**Notice of Exhibition of application for Sydney Metro – Western Sydney Airport (SSI 10051)**

Thank you for your referral dated 26 August 2020 inviting comments from the Heritage Council of NSW on the above State Significant Infrastructure (SSI) proposal.

Figure 7 | St Marys station– indicative cross-sections (Source: Submissions Report)

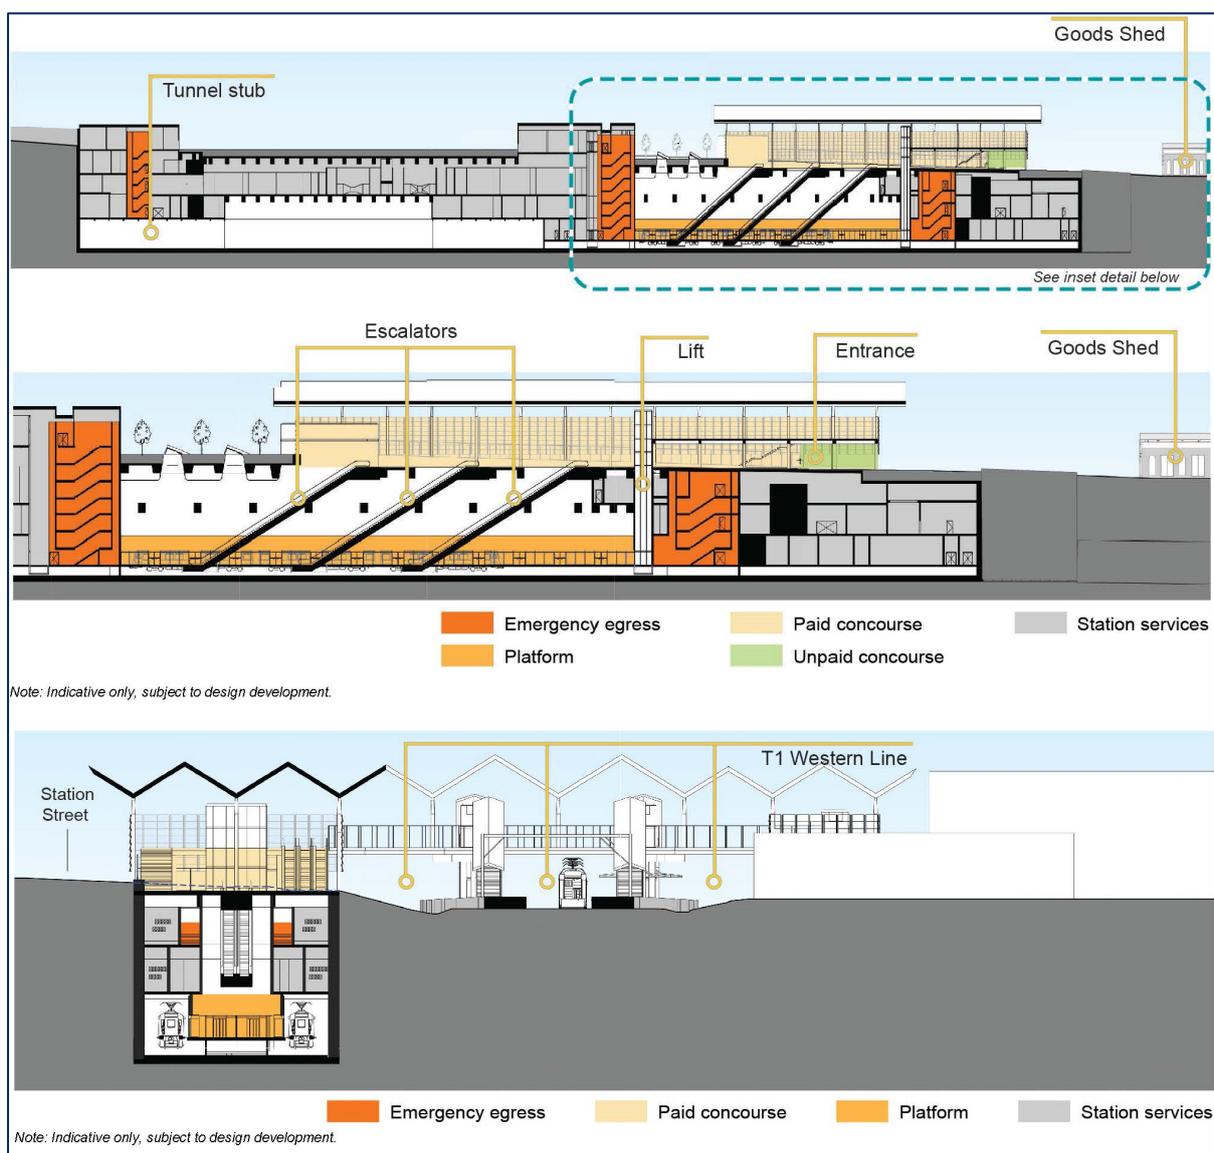
- The EIS does not include a detailed design of the proposed station – i.e. its exact location, bulk, form, scale and proximity to the significance elements of the St. Mary's Station group. It is therefore recommended that the applicant provide concept drawings, and details of the proposed station development in order to assist Heritage NSW in providing comments related to the proposal.

- The applicant is advised to ensure that the proposed station building:
  - Be sufficiently set back from the existing elements of exceptional, high and moderate significance to minimize visual impact on the St. Mary's Station Group.

- Be moderate in its scale and bulk.
  - Employ a sympathetic design aesthetic and utilise architectural devices that ensure that the proposed built elements are recessive and do not overpower the setting of St. Mary's Station Group.
